ASSESSMENT REPORT

SCECGS Redlands School Senior Campus Concept Proposal and Stage 1 Redevelopment, Cremorne SSD 6454 MOD 1

Figure 2 – Stage 1 Works as Approved / Modified

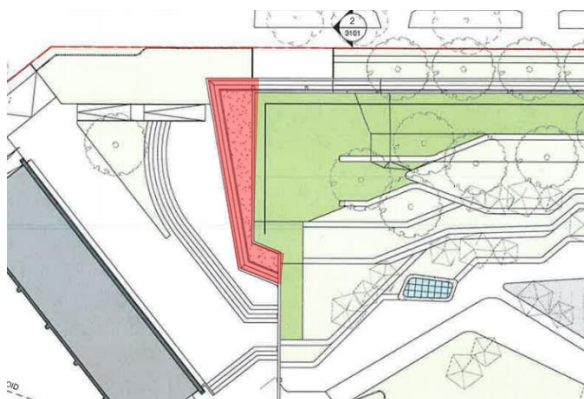
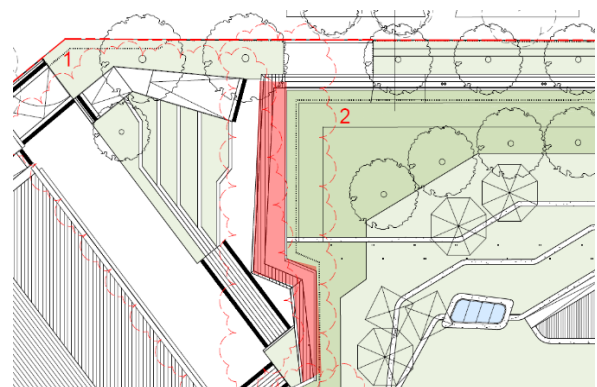
- Modification of the extent, profile and depth of the landscape podium roof overhang (Figures 4 and 5).

The proposed modification to the extent, depth and profile to the landscape podium roof overhang that is perpendicular to the Gerrard Street frontage of the building (as shown in **Figure 4**), is considered to be in keeping with the originally approved development. It is not considered that there will be additional detrimental impacts regarding solar access or amenity to the subject/neighbouring sites. Furthermore, the redesigned awning reduces the overall appearance of scale and bulk of the building towards the Gerrard Street frontage and provides greater cover as the building extends southwards into the site. Therefore, this alteration to the approved design is acceptable in this instance.

Picture 3 – Location of Mechanical Plant as approved and modified

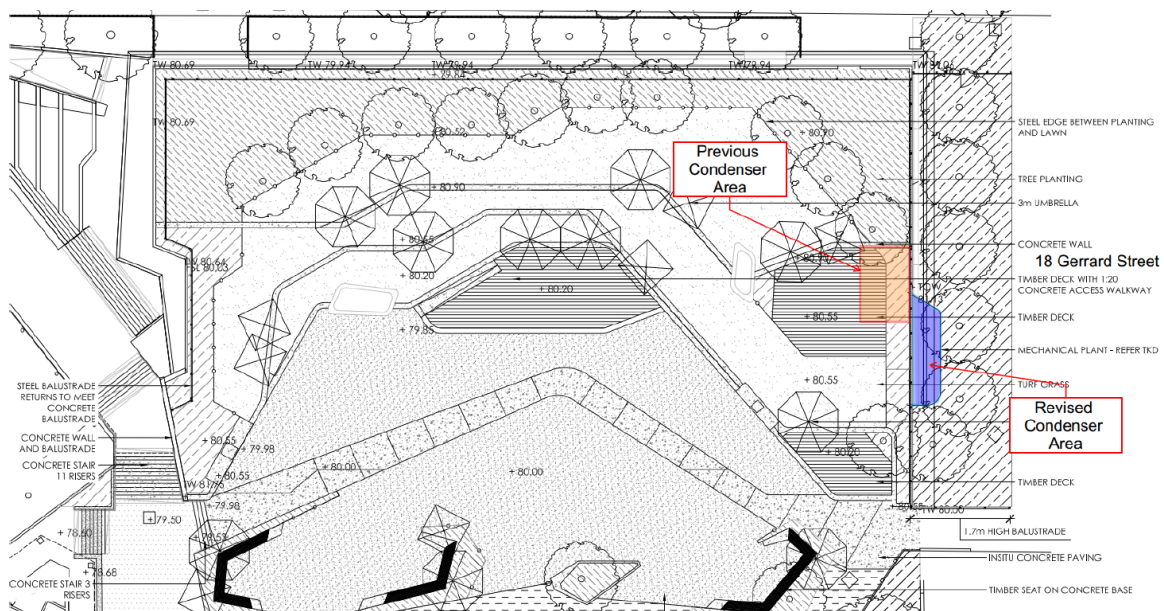
- Minor modifications to circulation routes, internal room configurations, and seating plans at the basement level (Interim Music Hub) to level 4.
- Minor modification to Stage 1 basement carpark layout including reduction from 63 to 61 spaces.
- Relocation of mechanical plant (condenser) to the eastern edge of the podium (Figure 3).

The location of the condenser unit as originally approved is shown in **Figure 3**. The application proposes to modify this location and move it closer to the eastern boundary shared with neighbouring residential units that front onto Gerrard Street. The Department originally imposed Condition B2. **Noise Attenuation Measures** which states the following:

The Applicant submitted as part of the modification application a letter from an acoustic specialist (Wilkinson Murray) outlining an acoustic review of the proposed location for the condenser unit. This assessment of the revised location for the condenser unit has shown that compliance can still be achieved as per the requirements of the original condition (F7 of the originally approved development)

- the condenser plant is in an area contained within the new carpark facility below ground level (and therefore, noise will be contained inside the carpark)
- the outlets will have 2D silencers installed on top of the unit
- the internal walls will be lined with acoustic absorption material
- the units that may operate in the evening are to be set on night mode to further reduce noise impacts generated.

The Department considers that despite the location of the condenser unit being shifted closer to the boundary, the new location is still governed by the requirements of the noise conditions as discussed earlier in Section 3.1 of this report. Furthermore, supporting documents provided show that the condenser unit can comply with the requirements of the condition. The neighbouring residential properties affected by the relocated condenser were notified of the application and no submissions were received in objection.

Picture 4 – Entry forecourt design as approved

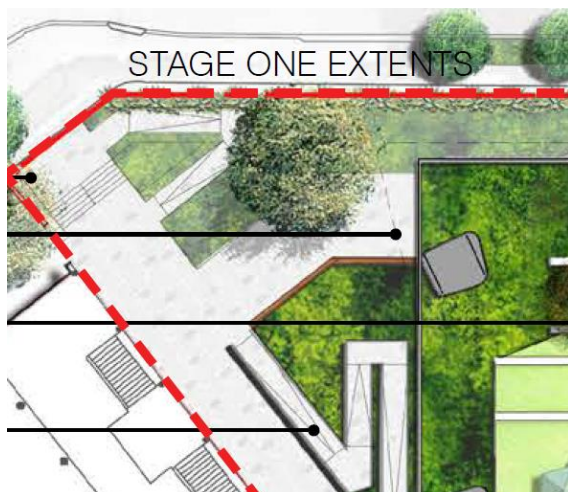
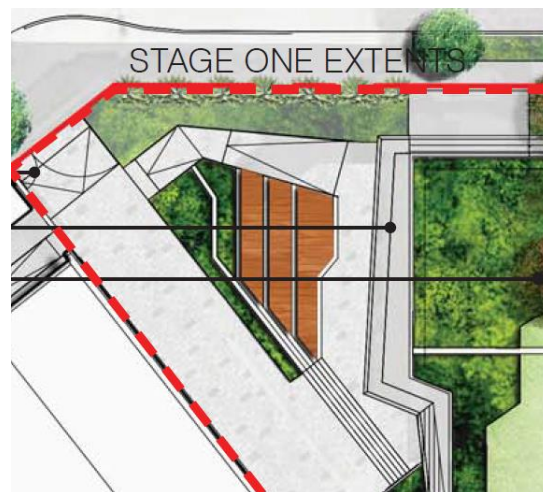
- Minor modification to the entry forecourt (ramp and stair configuration) (Figure 9).

The proposed modification to the forecourt area adjacent to the new pedestrian entry at Gerrard Street is similar to what was originally approved. The modified access ramps (leading from the forecourt) and pedestrian circulation paths are still considered to provide access within the site in a similar fashion to what was originally approved. Furthermore, this modification will not have any detrimental impacts towards the public domain.

Picture 7 – Podium landscape design as modified
Source: Silk Consulting Landscape Architects

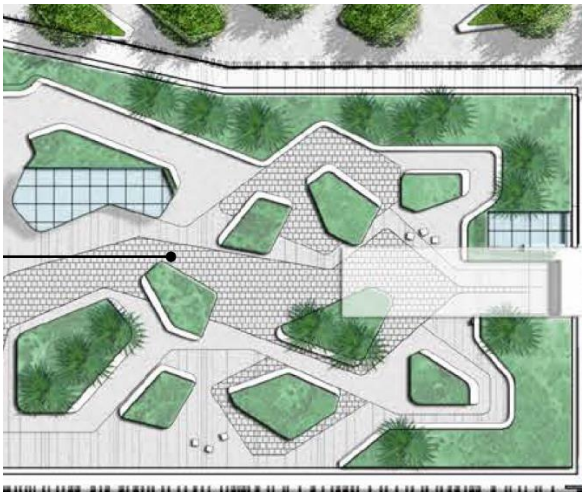
- Reconfiguration of podium and rooftop landscaped areas (**Figures 10 and 11**).

The podium and rooftop landscape modifications are related to changes in the design as to how the space is used, how pedestrian circulation is conducted and the materials types. The proposed modifications are in keeping with the overall character design of the originally approved development, do not alter the use and will not be readily visible from the public domain at street level.

Therefore, the proposed landscape modifications to the abovementioned locations are considered to be acceptable in this instance.
